Summary of Written Representations
from the
Royal Society for the Protection of Birds

**Submitted for Deadline 1
18th November 2025**

**Application by National Grid Electricity Transmission for the
Sea Link Project**

**Planning Inspectorate Ref: EN20026
The RSPB Registration Identification Ref: F5280E651**

Legend

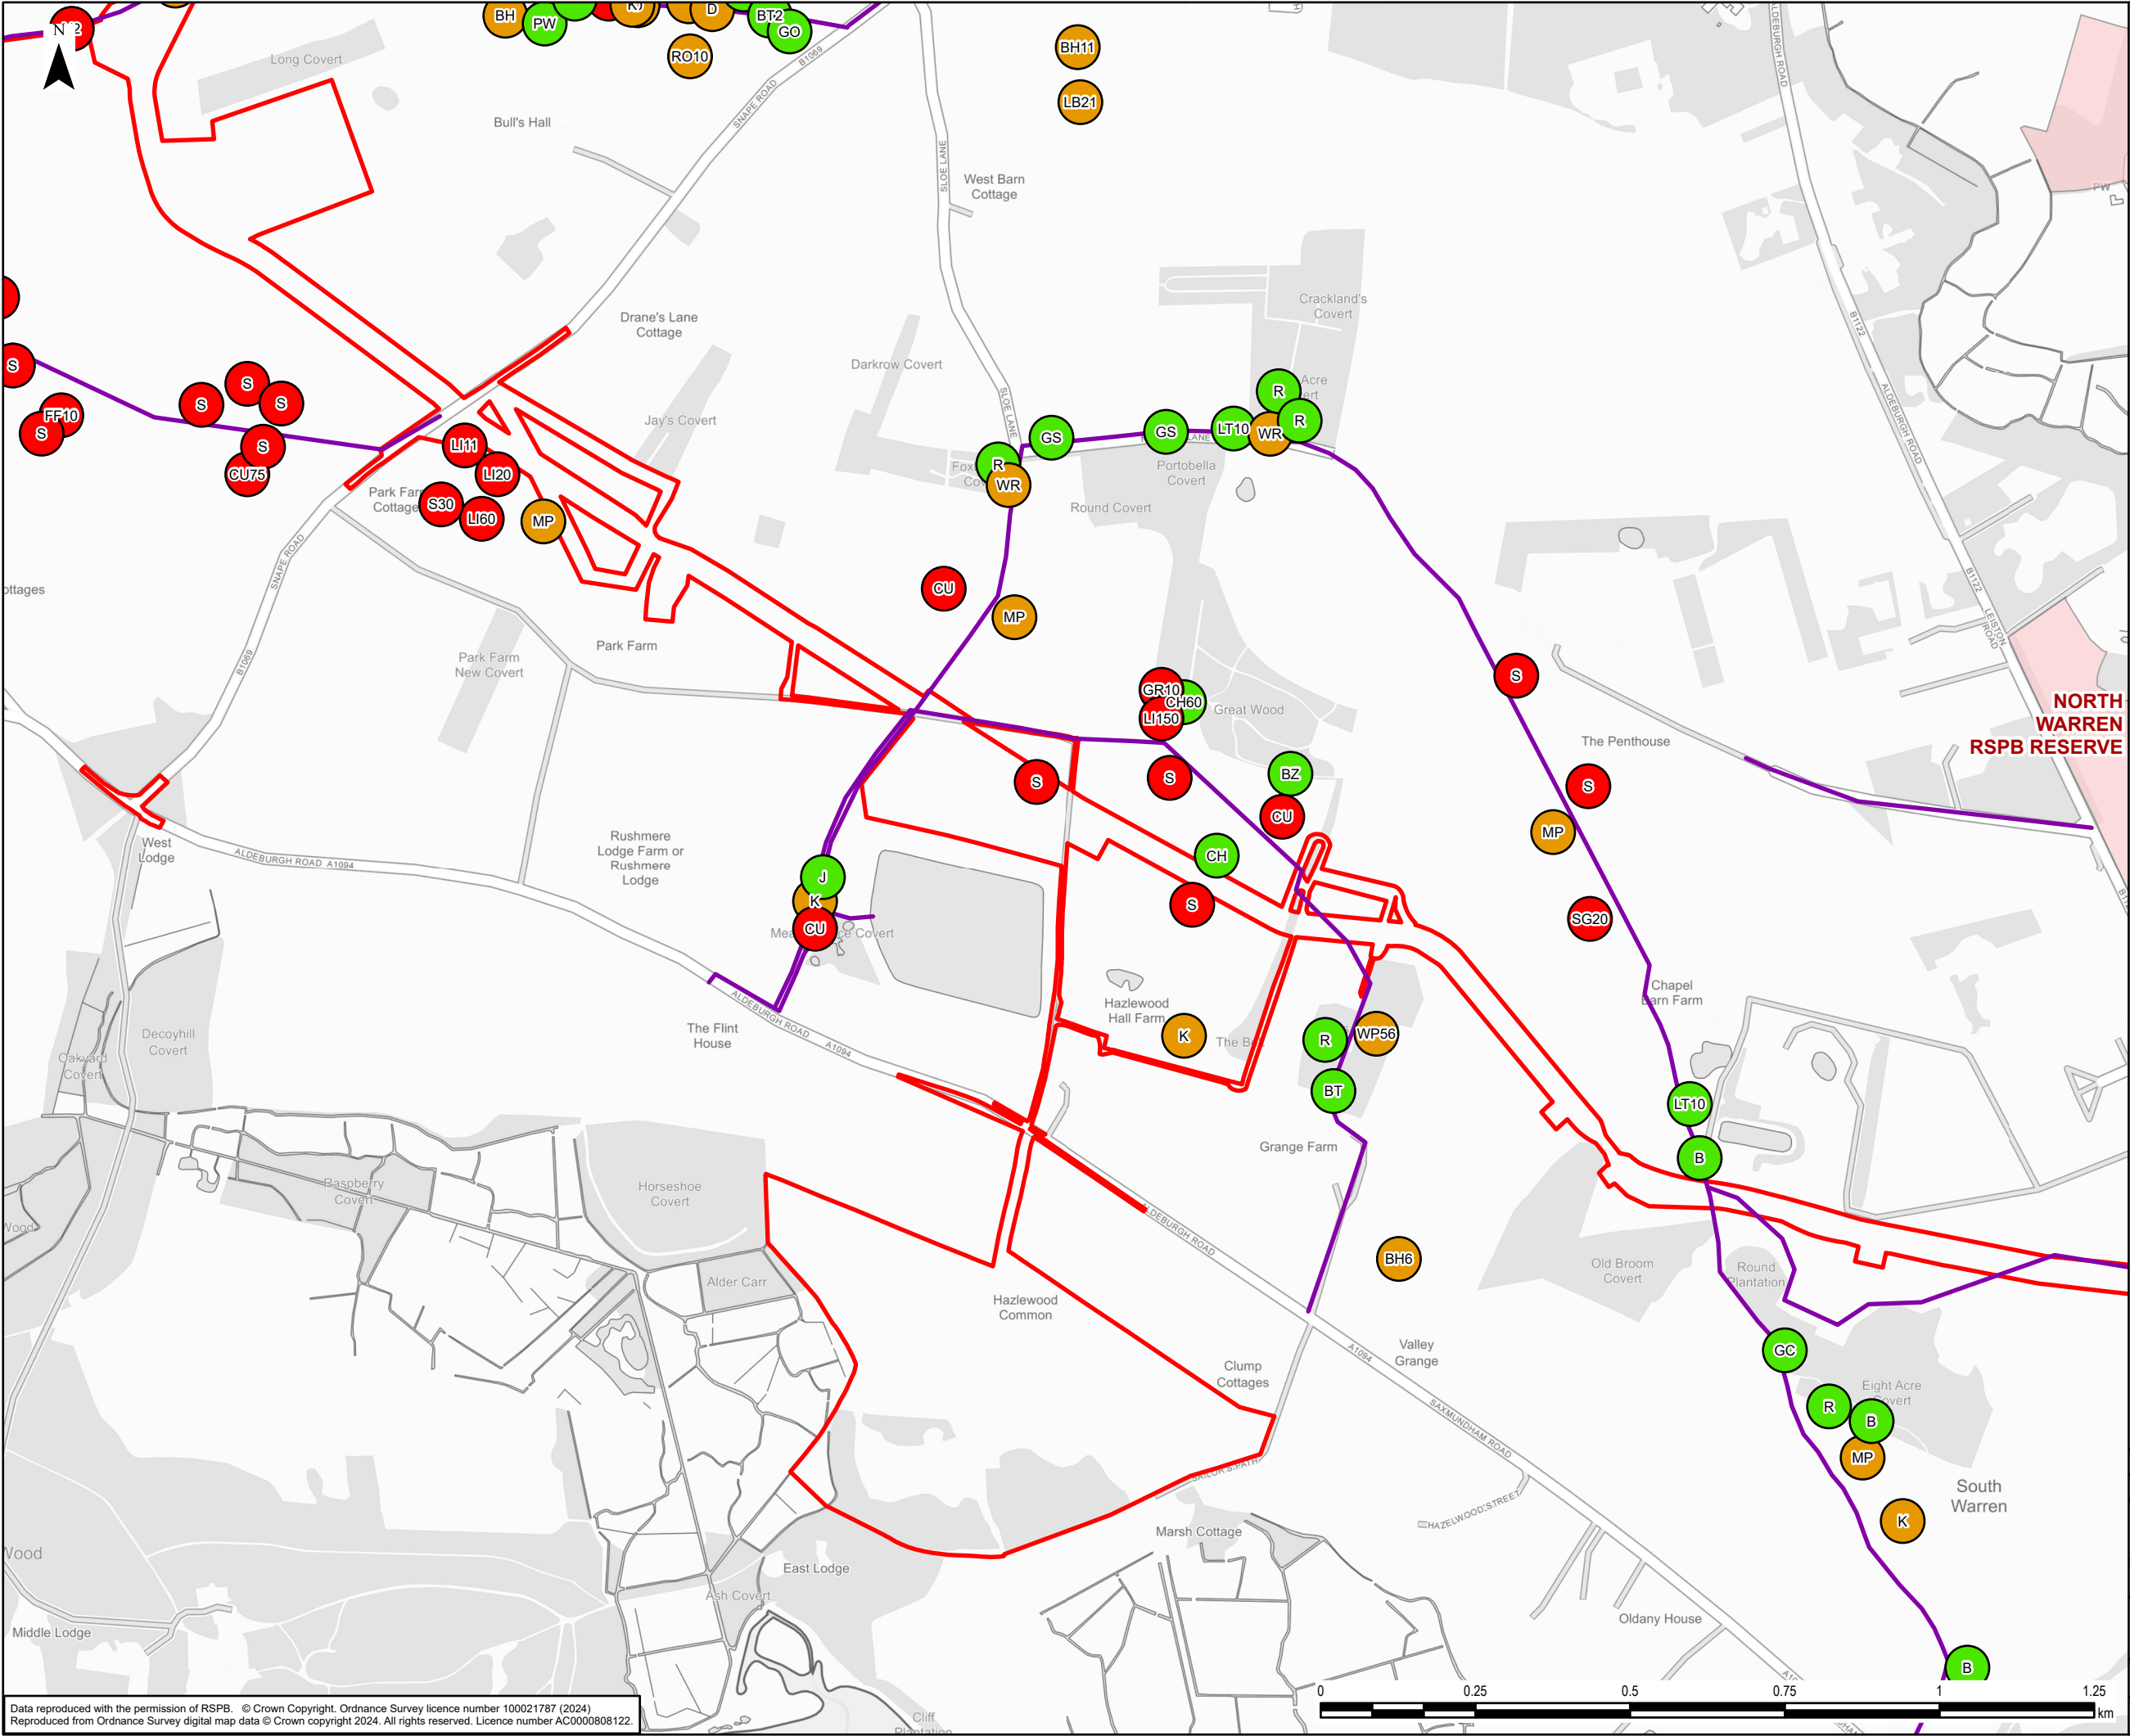
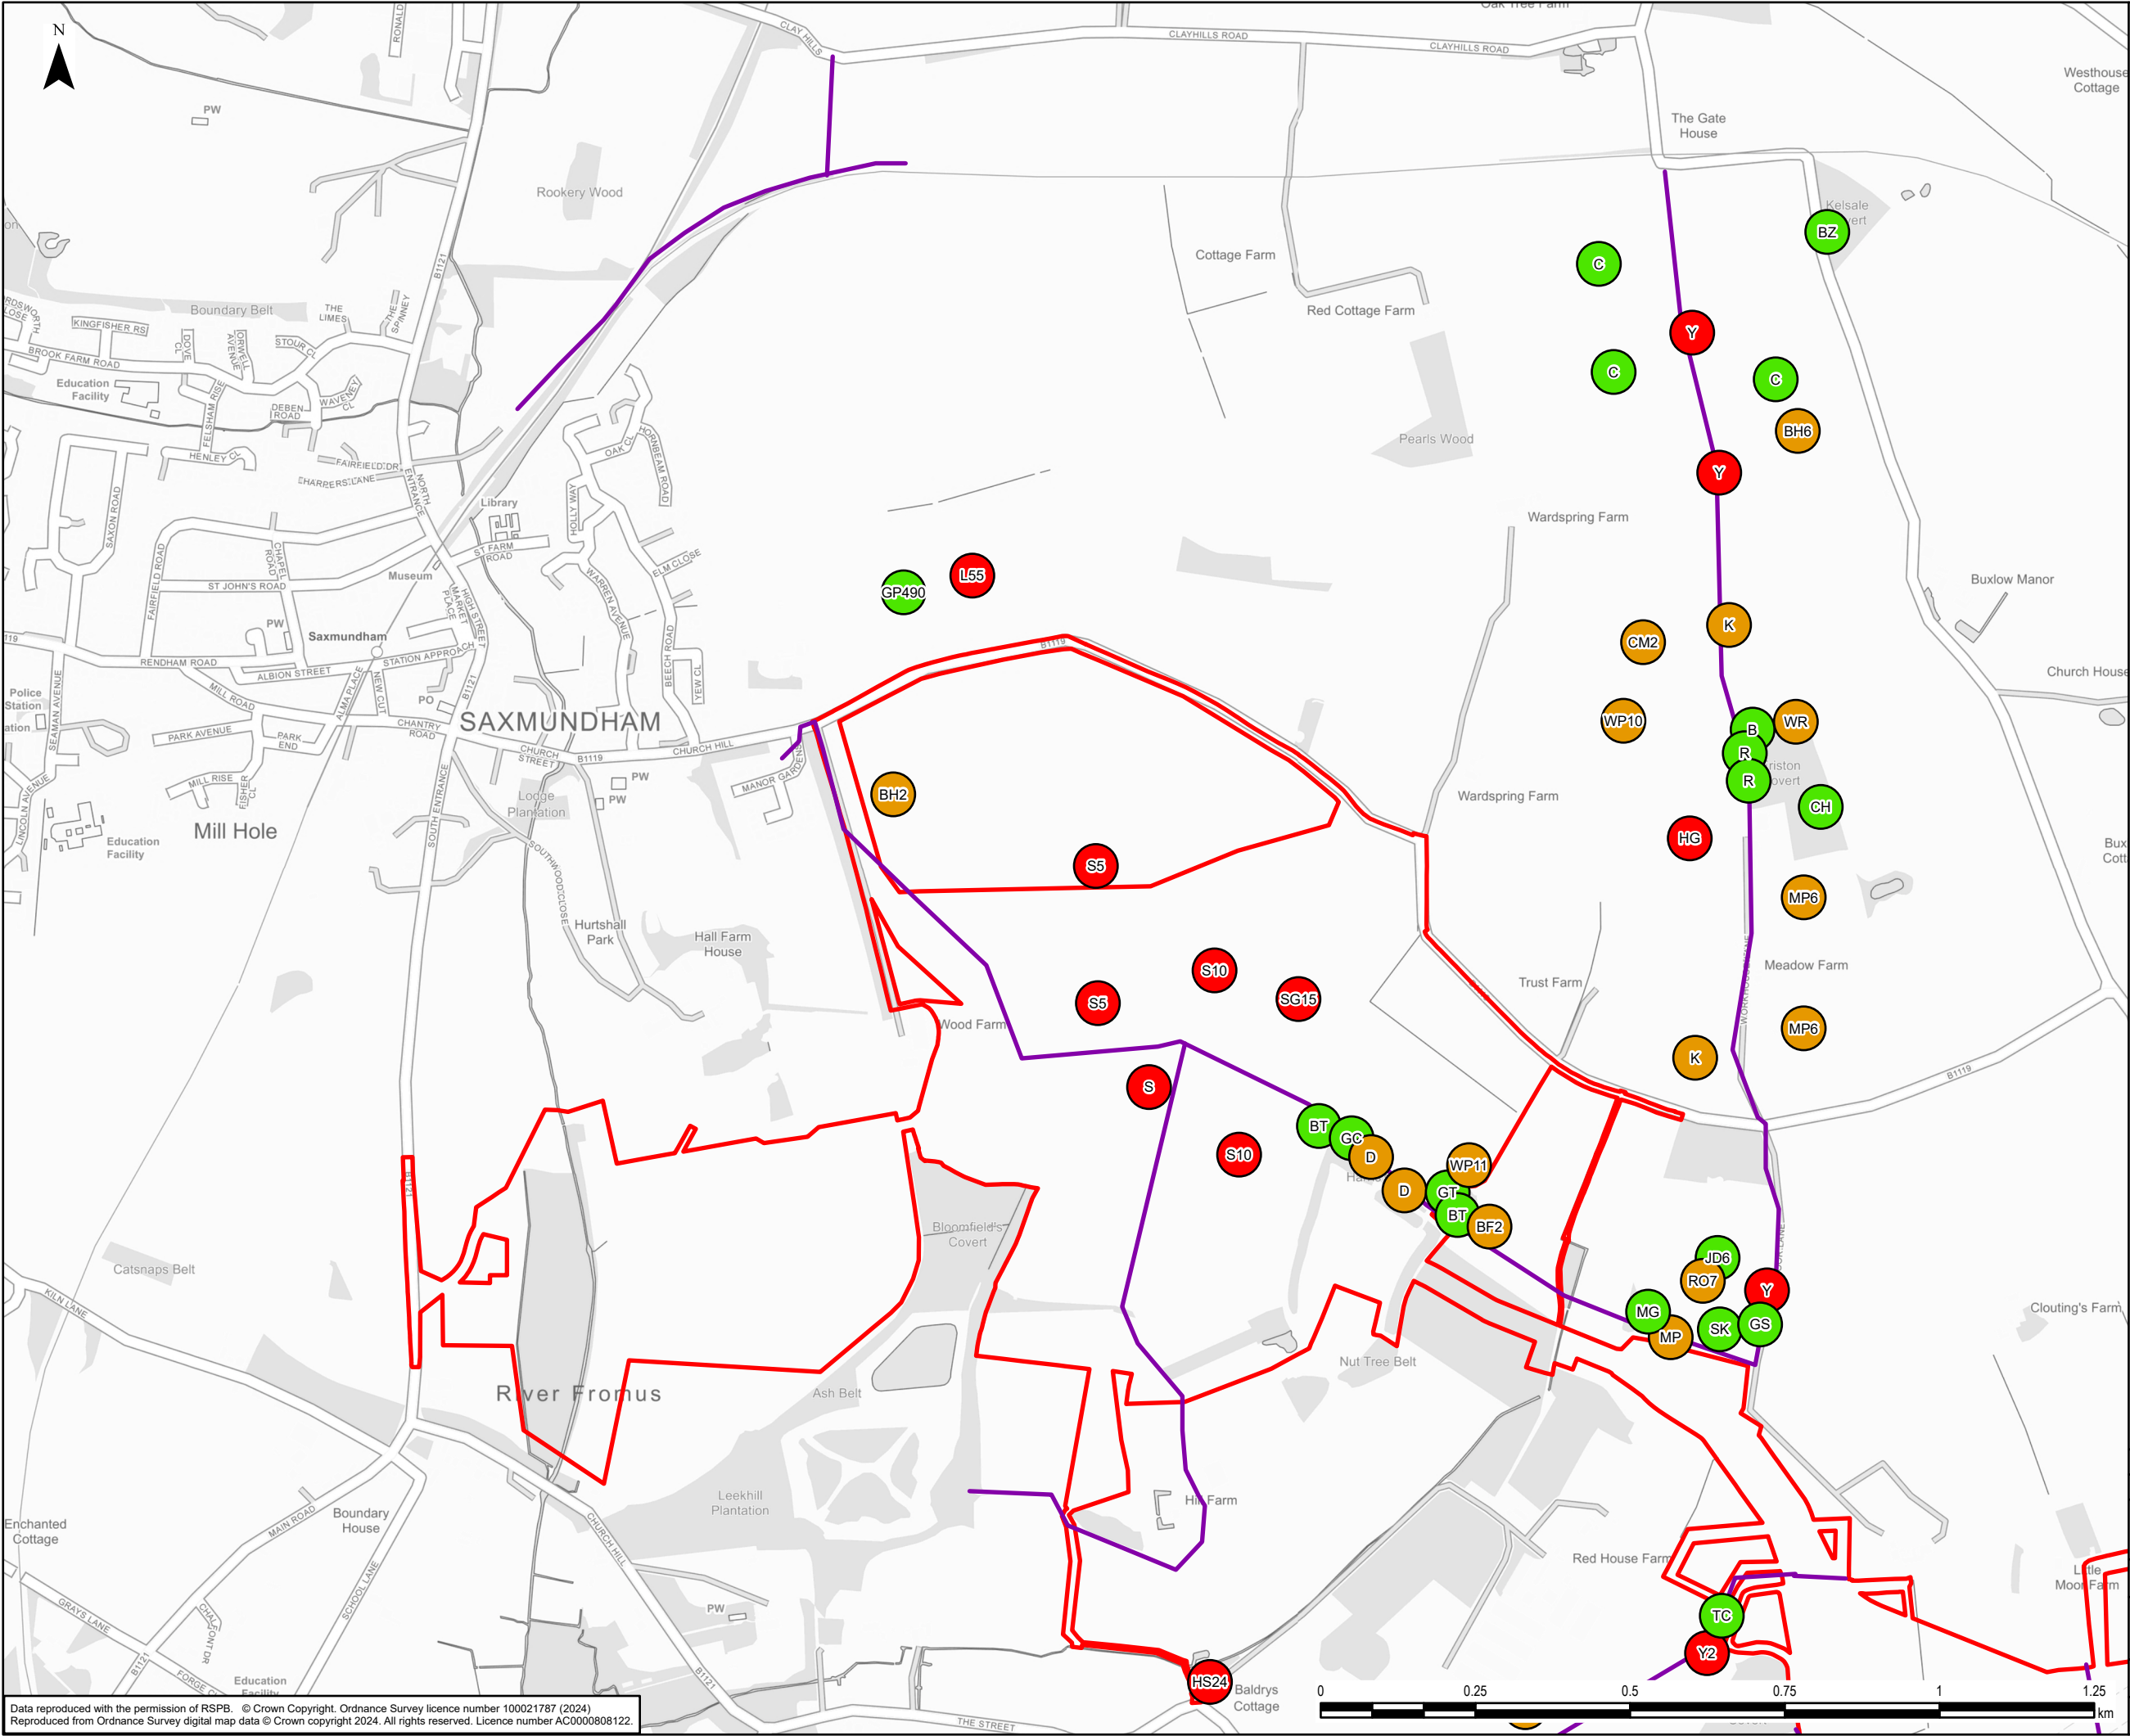
- For the 2024 Lapwing and Redshank figures, methods and limitations should be discussed and it should be acknowledged that the territory distribution maps may not accurately reflect the real locations of favoured areas.
- Maps used to show the abundance and distribution of wintering birds recorded during 2022/23 in [APP-216](#) should clearly indicate that the wet grasslands were not formally surveyed on the dates shown in the legend.
- Annex 2.B.2 (p63, ep67) of [PDA-025](#) ES Appendix 2.2.B Suffolk Wintering Bird Report is a compendium of WeBS data from Kent and not Suffolk and requires correction.
